Historic England

**VICTORIA TOWER, LUMB LANE, CASTLE HILL, ALMONDBURY,
HUDDERSFIELD, HD4 6TA
Application No. 2018/93591**

We have received Amended information (consisting of a revised Heritage Statement (UrbanGlow and One17 Architects, March 2021)) concerning the application for the proposal to develop a cafe/restaurant with bedrooms, interpretation facilities and associated parking and servicing at the nationally important Scheduled Monument of 'Castle Hill: slight univallate hillfort, small multivallate hillfort, motte and bailey castle and deserted village', NHLE 1009846.

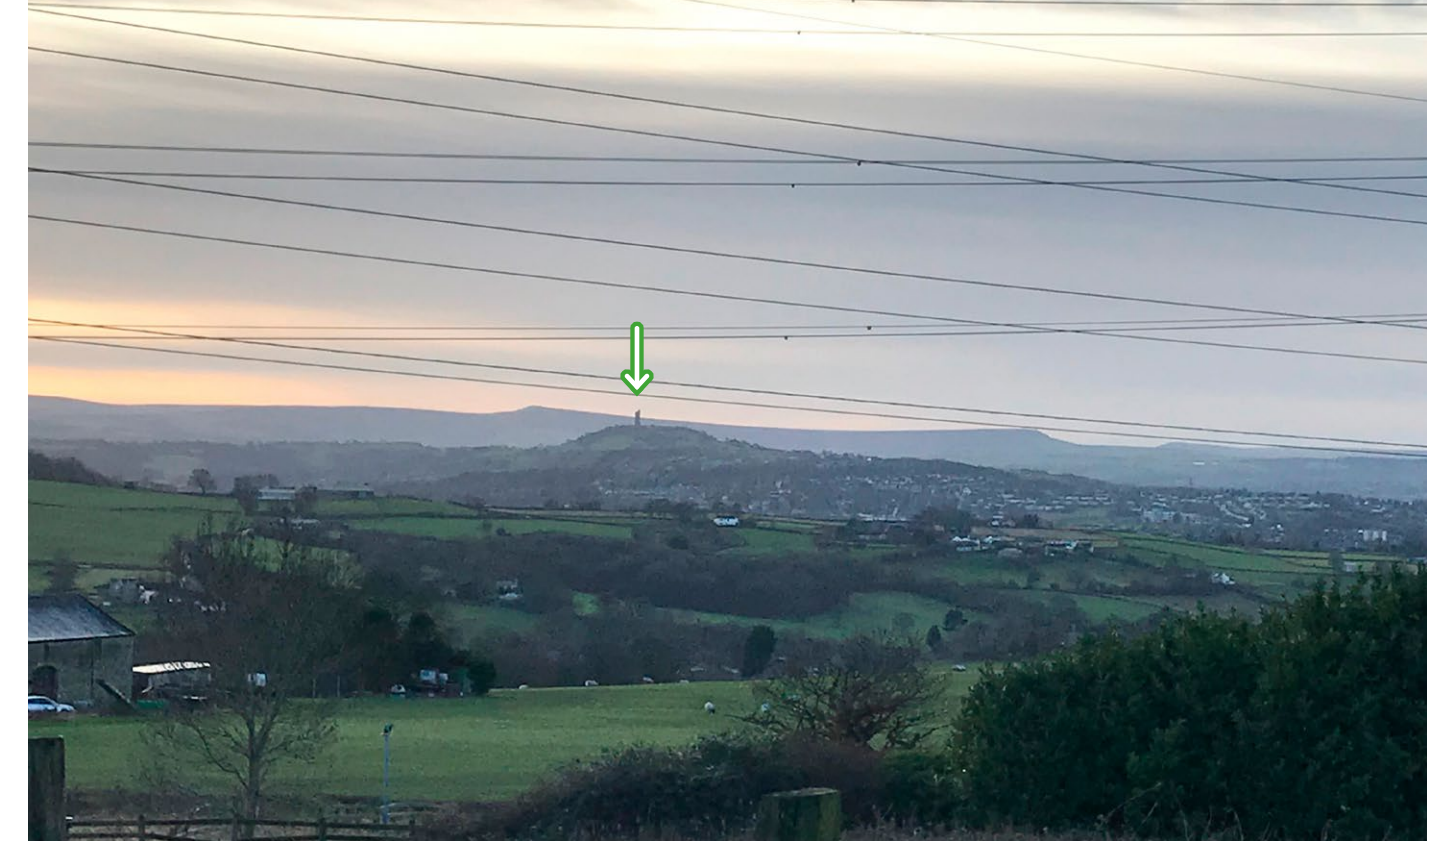
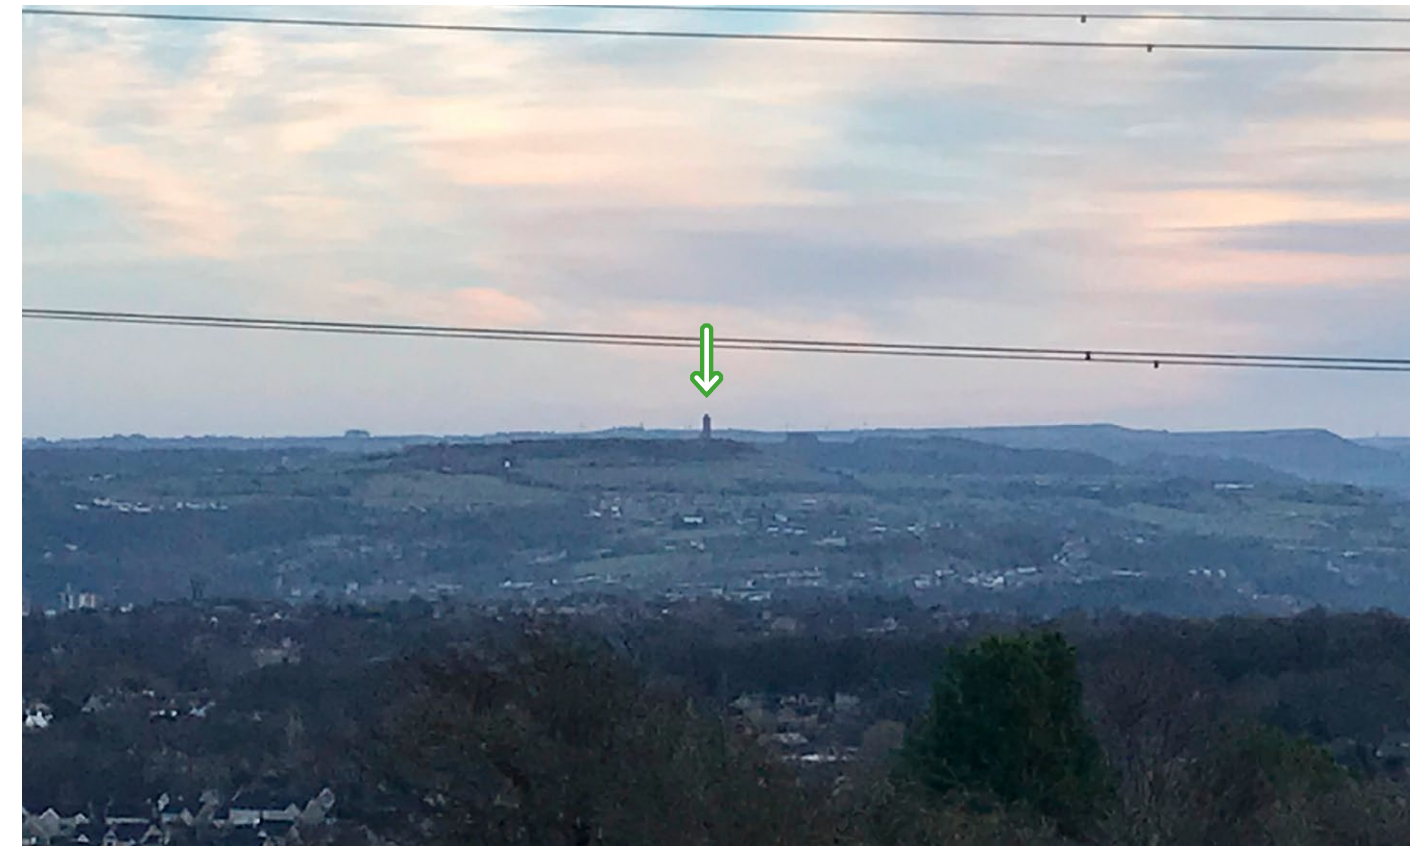
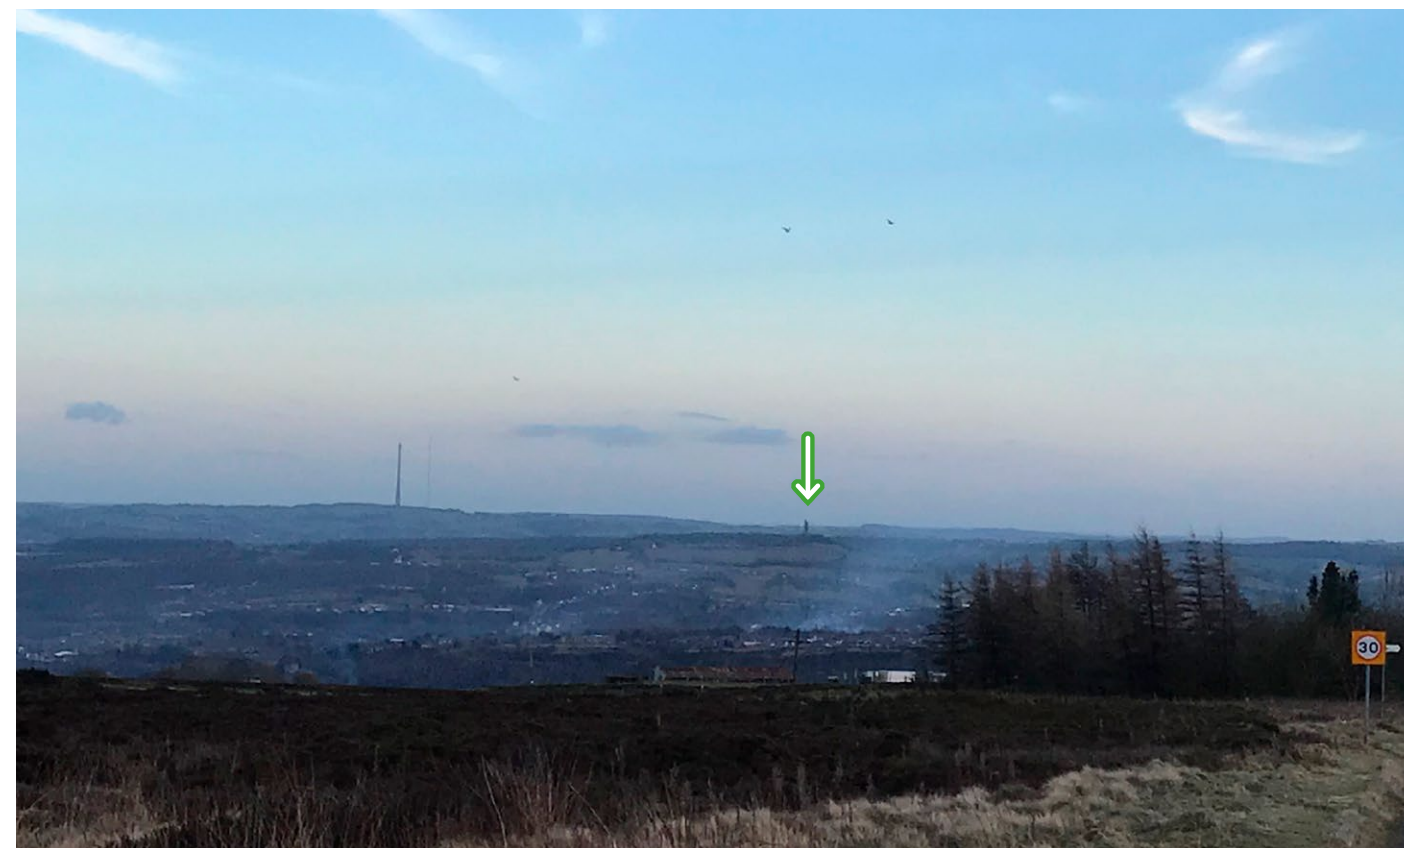
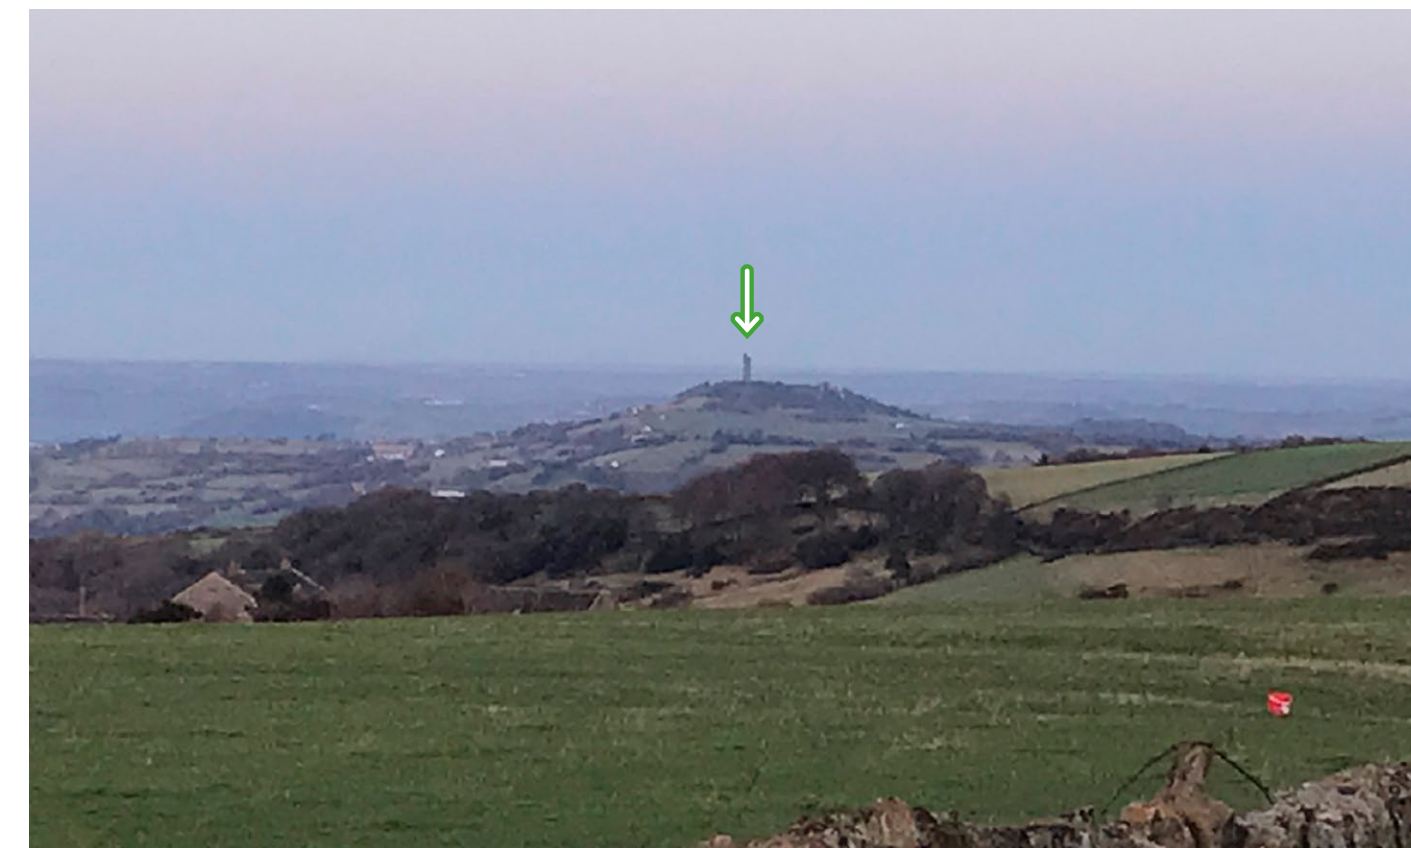
- 2) **Setting:** The additional visualisations and views from new locations around Castle Hill (viewpoints 1 to 16) are a welcome and useful addition and provide a more comprehensive illustration of the impact and visibility of the scheme. However, the Heritage Statement has not been updated in accordance with the NPPF or the published guidance on Setting.
